Our ref: DOC20/294527

Your ref: SSD-10285

Subject: EES comments on Response to Submissions – Royal Randwick Racecourse – Leger Lawn Development – SSD-10285

- Response to Submissions – 9 April 2020
- Revised Landscape Plan – Issue E – 22 January 2020

DRAWING
LEVEL 1 MASTERPLAN

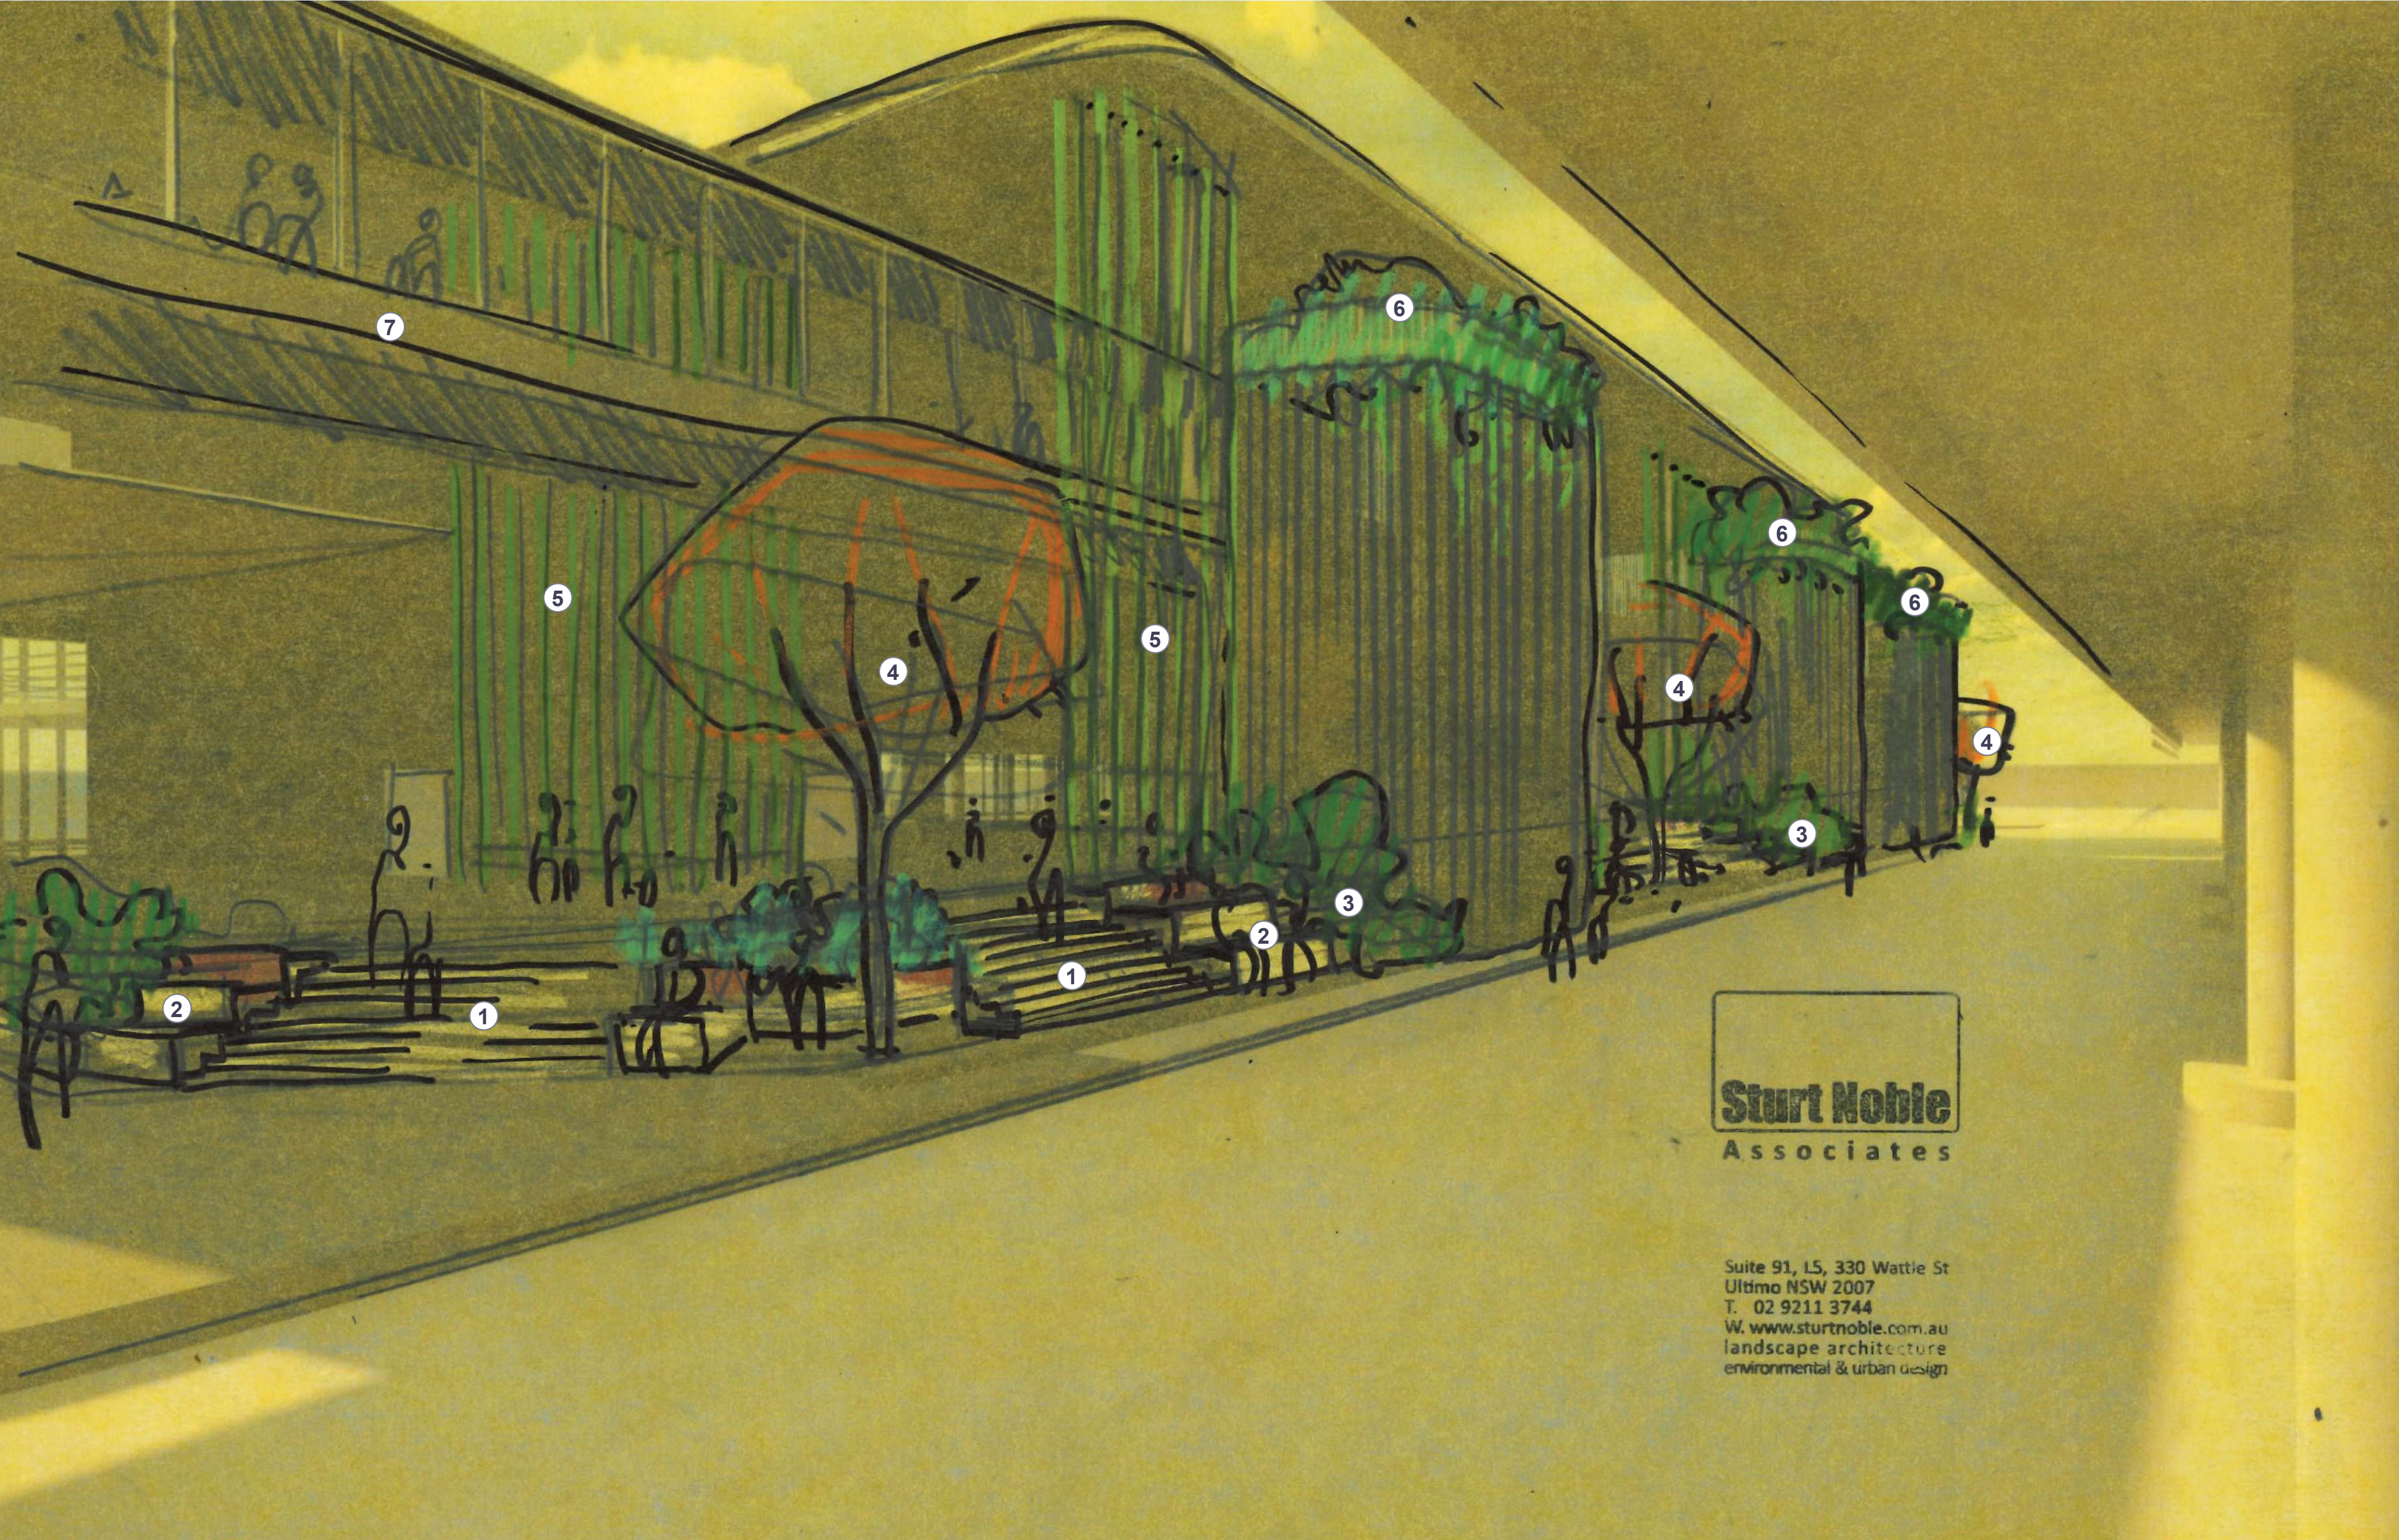
EES notes the Revised Landscape Plan has removed Red Hot Poker from the plant species list but exotic species such as Japanese Box and 'Magnifica' Gardenia are still proposed to be used. It is noted however that *Buxus sp.* are to be used on level 1 of the Winx Stand as a formal hedge and the RTS states it is not invasive (page 52 of RTS). The EES submission did not state that Japanese Box was invasive but rather that it is an exotic species (i.e. non-native). Where landscaping is proposed at ground level it is recommended local native provenance plants are used.
